20th November, 2018

**Re: Application BR/254/18/A 4 Non-illuminated advertisements,
Hothamton Gardens & Surrounding Areas, Bognor Regis.**

DRAWING TITLE
GENERAL PROPOSALS

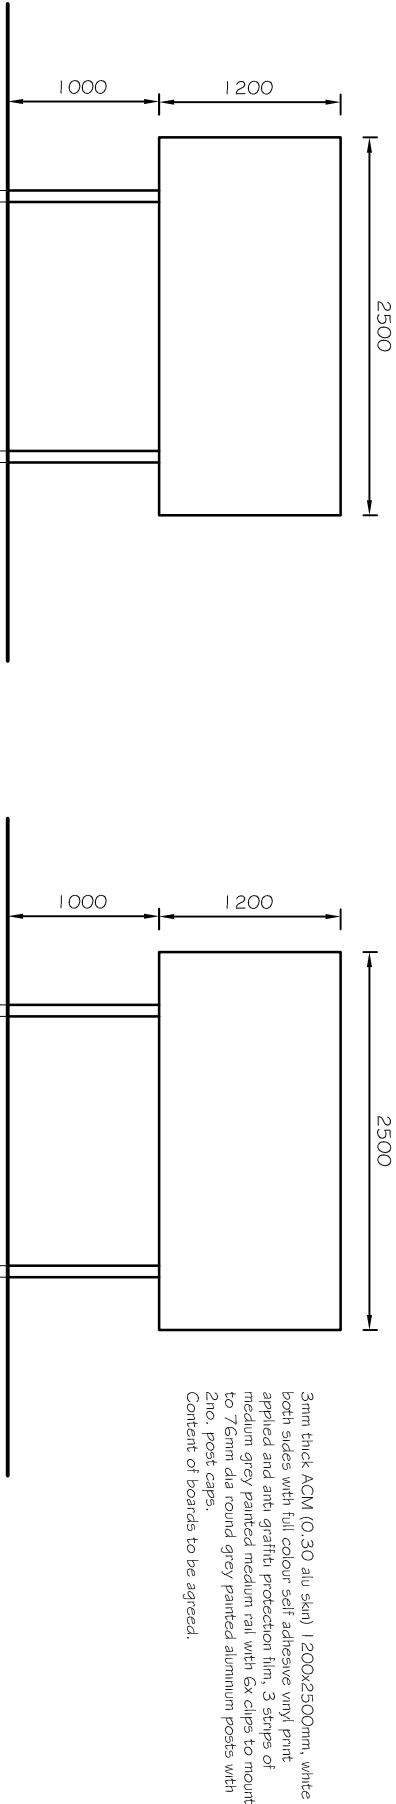
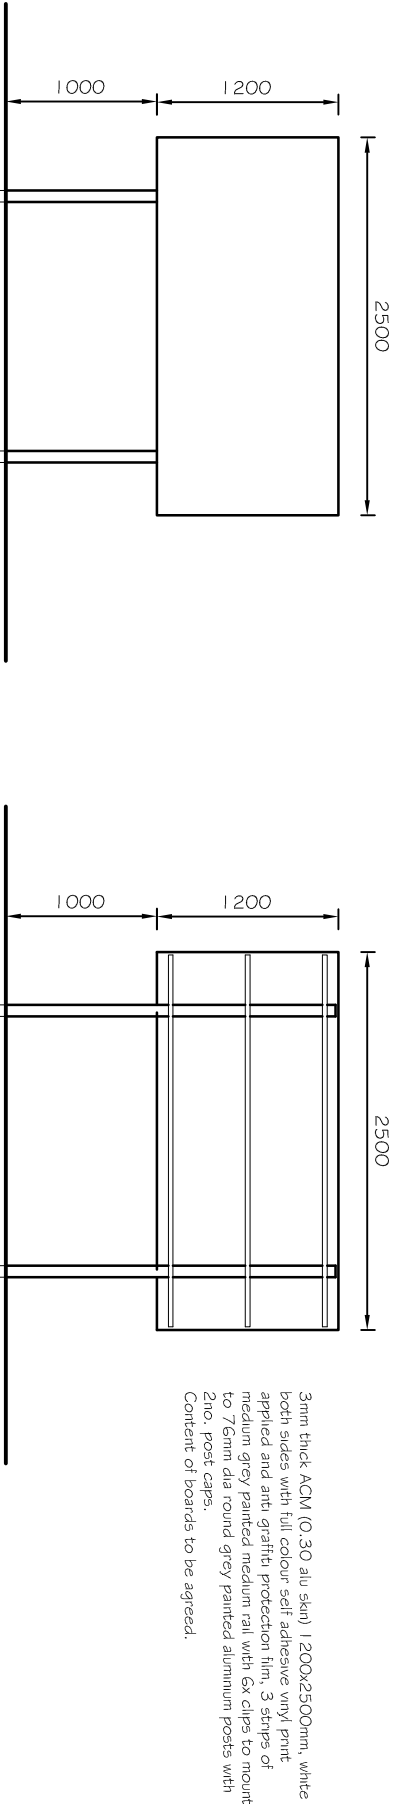
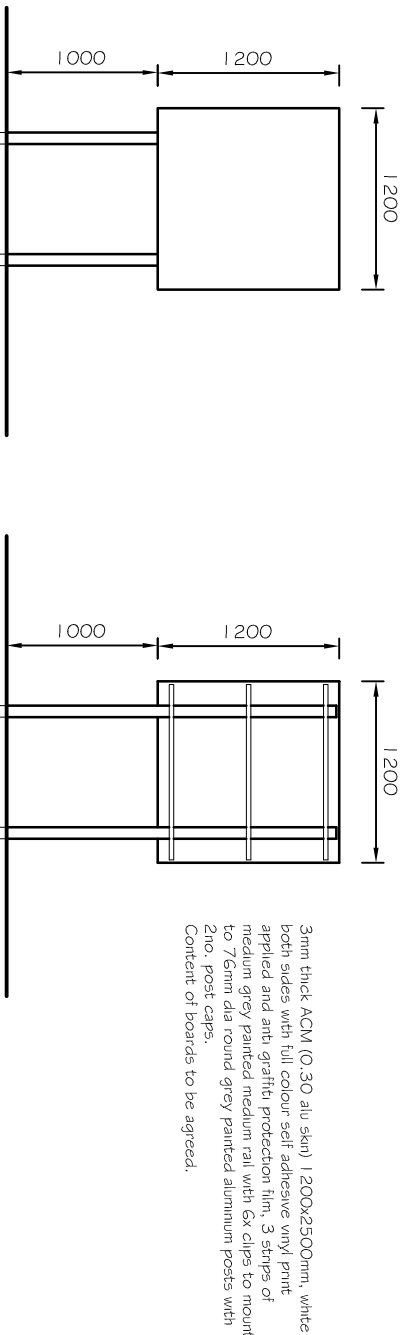
- 1a** Under class 3C(1) (Conditions and Limitations) the regulations state that: "not more than one advertisement shall be displayed at any one time on each road frontage of the land..." In this application a sign is placed on the Queensway frontage on the North East corner of the land. A sign is also placed on the junction of Queensway and Canada Grove/Argyle Circus. This latter sign is also double sided, and thus must in addition qualify as two signs. All of this breaches the regulations.

1c Excessive size. All the proposed signs are to be positioned less than 10 metres from the highway, and there is no indication as to content and therefore no indication that they relate to more than 1 person. Under Class 3C(3)(a)(ii) the signs are therefore limited to 2 square metres maximum. The application plans show that three of them [North West corner (A), North East corner (B) and South East corner (C)] exceed this measurement. Class 3C(3)(a) also states that "no advertisement may exceed in aggregate---" The sign proposed for the North West corner (A) is double sided and therefore in aggregate considerably exceeds the maximum allowed of 2 square metres. The signs therefore breach the regulations and this application should be refused.

2a Public Safety. All four of the proposed signs are to be immediately adjacent to the highway, and three of them are excessively large for these locations providing considerable distractions to road users (including pedestrians) at points where there are already challenging circumstances with vehicles and foot traffic arriving from several directions at once (including car users leaving/returning to the car park on foot). These are the Queensway/Crescent Road/exit from Multi-storey junction (Sign B), the Queensway/Canada Grove/Argyle Circus junction which also has a bus stop close by (Sign A), and the east side Waterloo Square/West Street/High Street junction (Sign C). Public safety is paramount and certainly takes precedence over the known trivial intended purpose of these signs, and for this reason alone this application should be refused.

DRAWING TITLE
SITE LOCATION AND BLOCK
PLANS

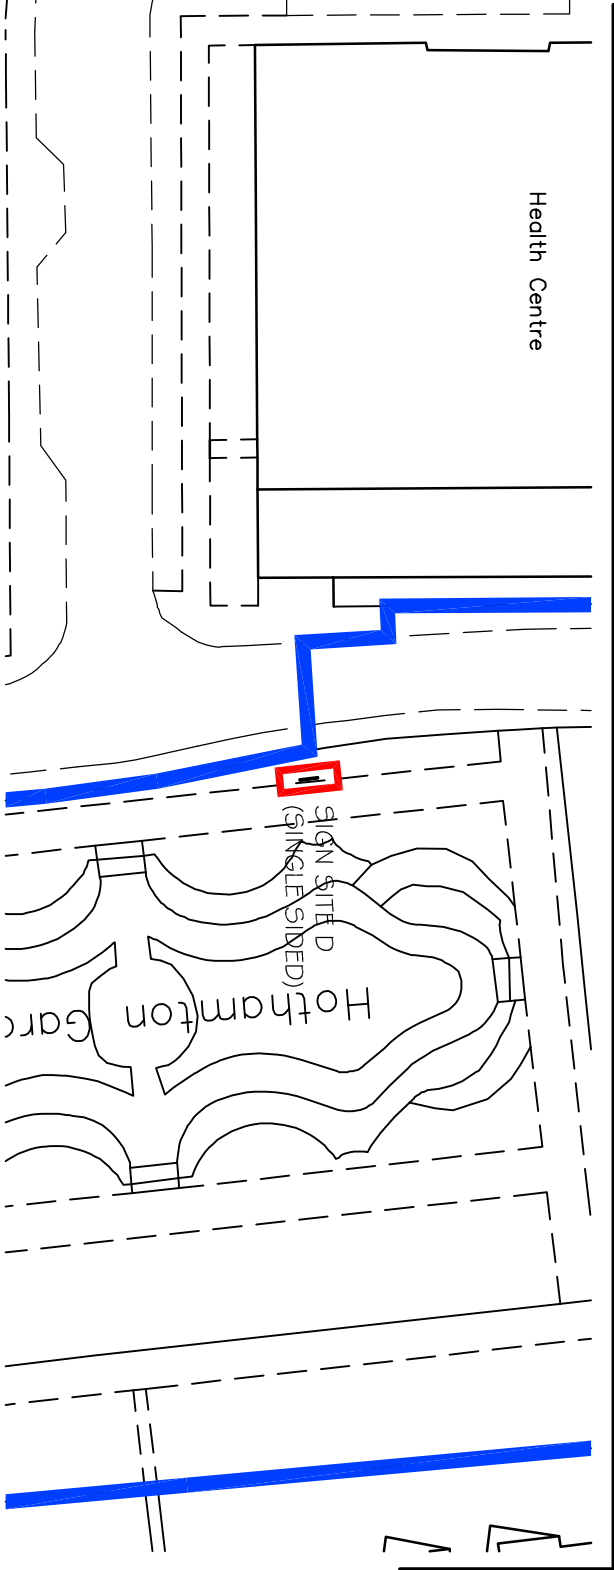
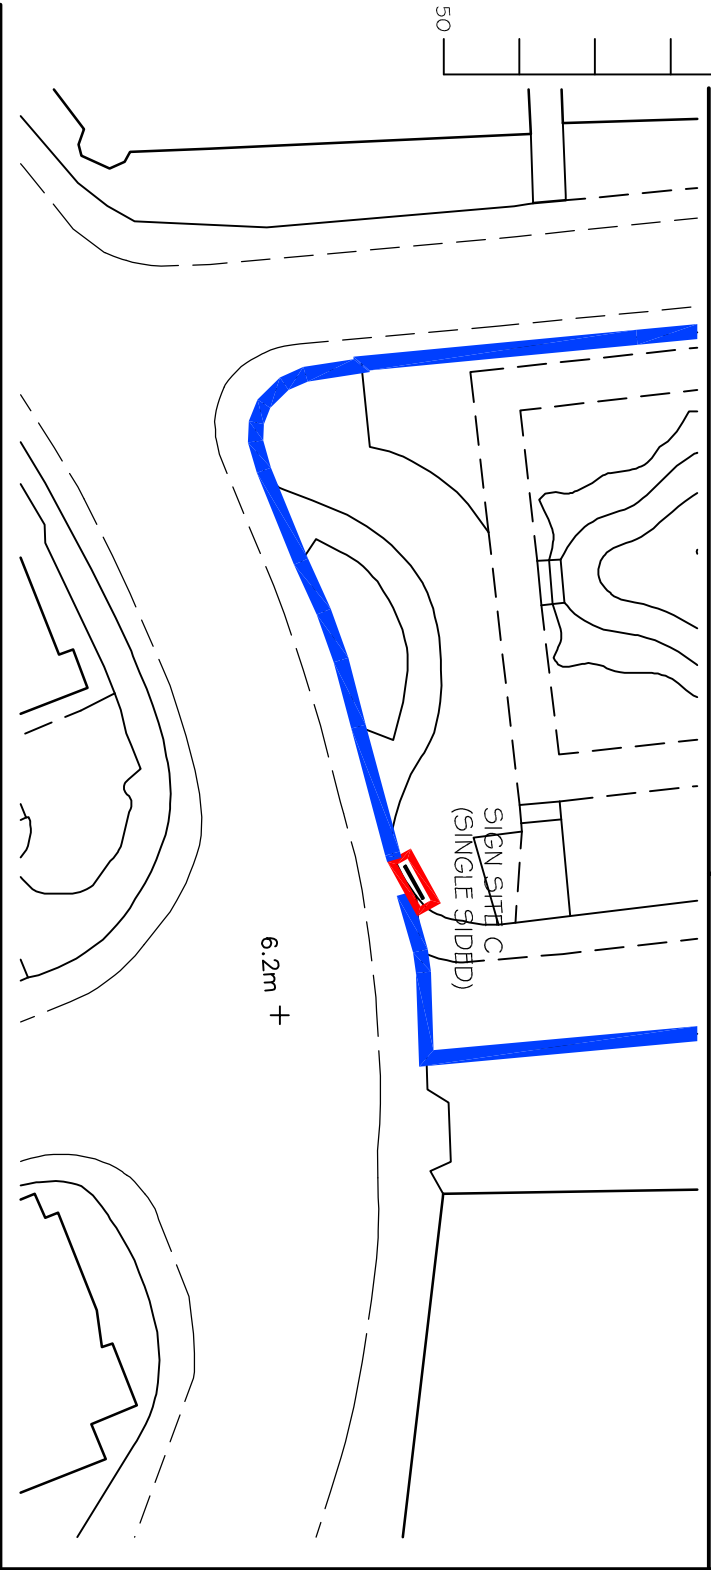
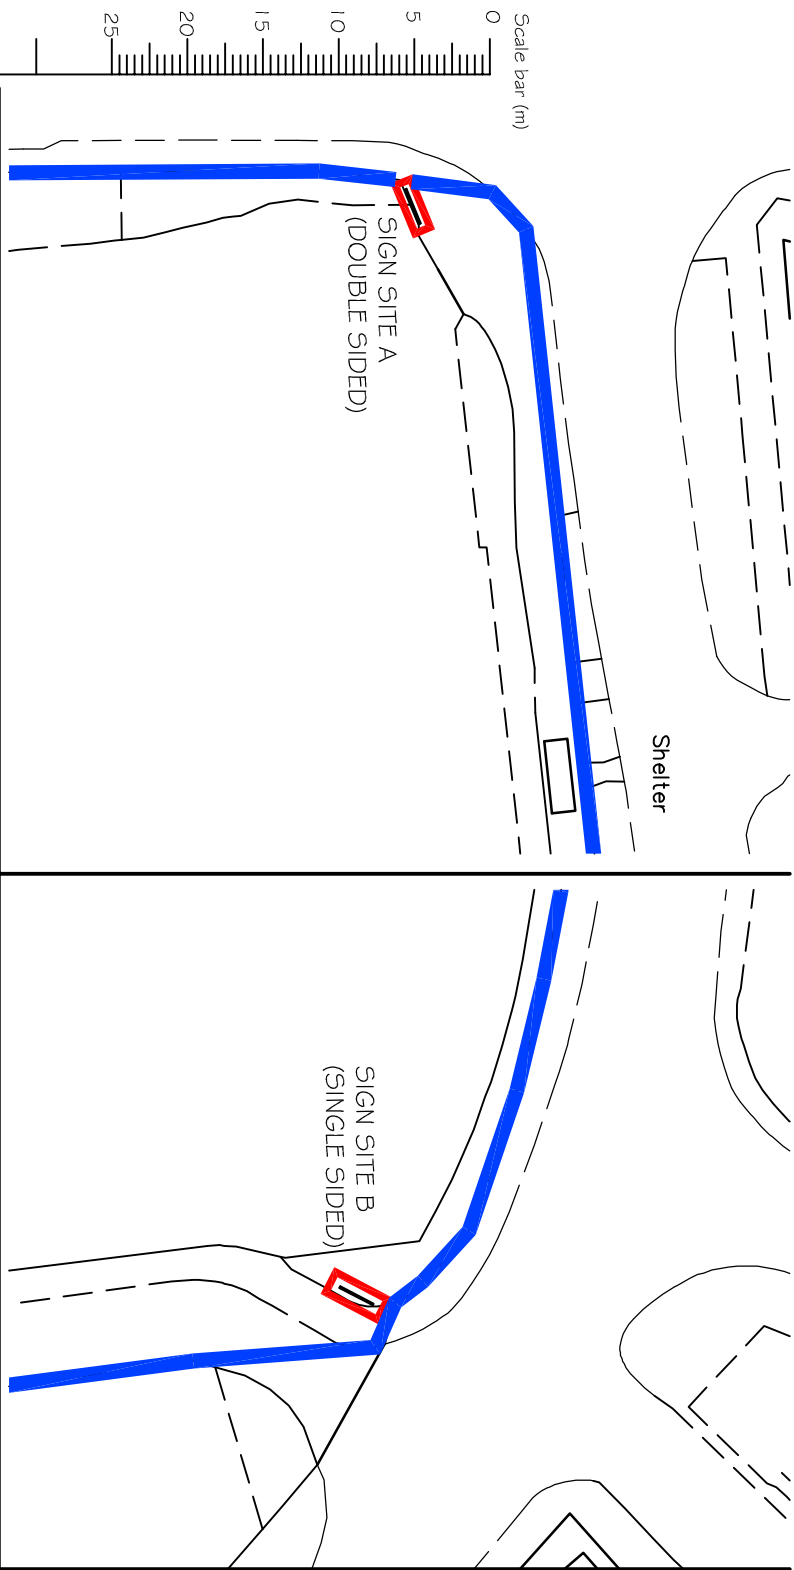
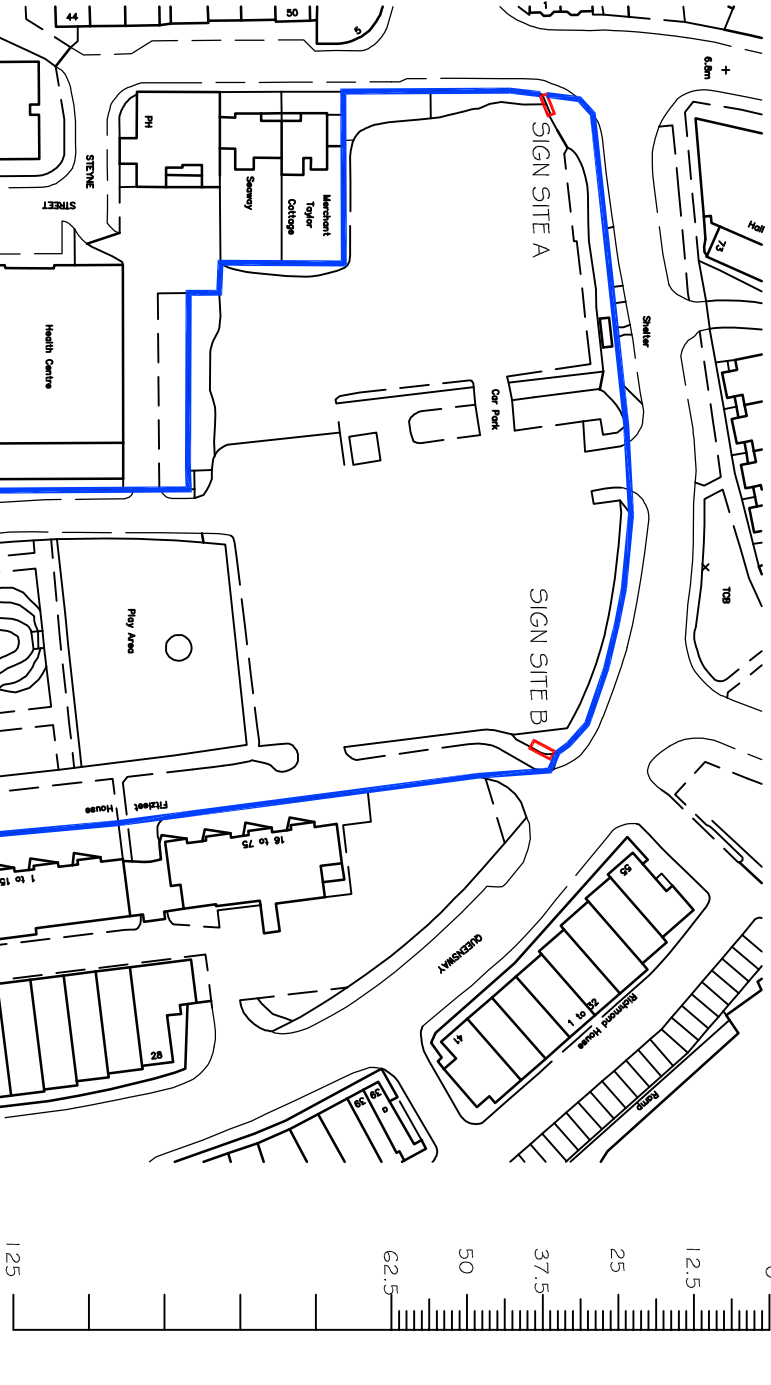
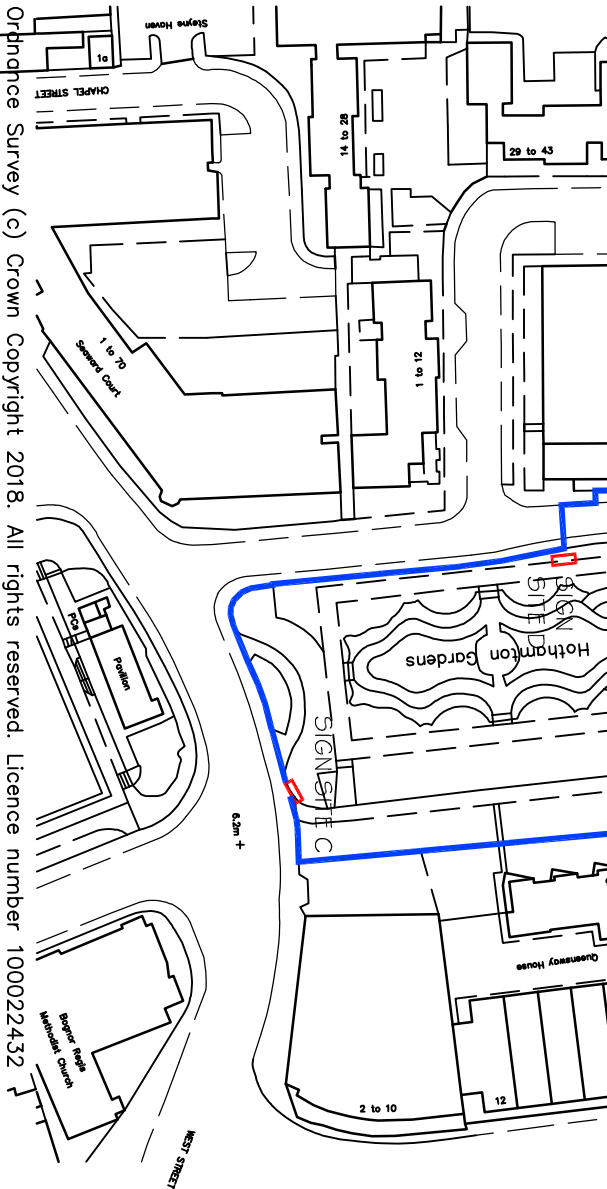
2b Amenity. Government guidance on amenity is available in Government Circular 03/2007, also the Communities and Local Government booklet "Outdoor Advertisements and Signs: A Guide for Advertisers." In reference to these there are statements such as: "in assessing amenity, the planning authority will always consider the local characteristics of the neighbourhood" and also "In practice, 'amenity' is usually understood to mean the effect upon visual and aural amenity in the immediate neighbourhood of displaying the advertisement." Two of the proposed signs will significantly clash with the nature of their immediate neighbourhoods. Sign C (South East corner of the site) is immediately adjacent to and faces onto a conservation area, and also is placed in a spot among the plants and greenery of the sunken gardens, with no buildings anywhere adjacent. In addition it is large, and is very clearly damaging to the amenity of the site itself. Sign D (West boundary of the gardens) again is placed within a backdrop of plants and greenery on the edge of the gardens, no buildings adjacent, with no thought as to the amenity and

verdant appearance of its site, which it immediately destroys. If the Planning Authority has any consideration for the amenity of the gardens, **as is required by government guidance**, it will not permit these signs to be placed in those locations.
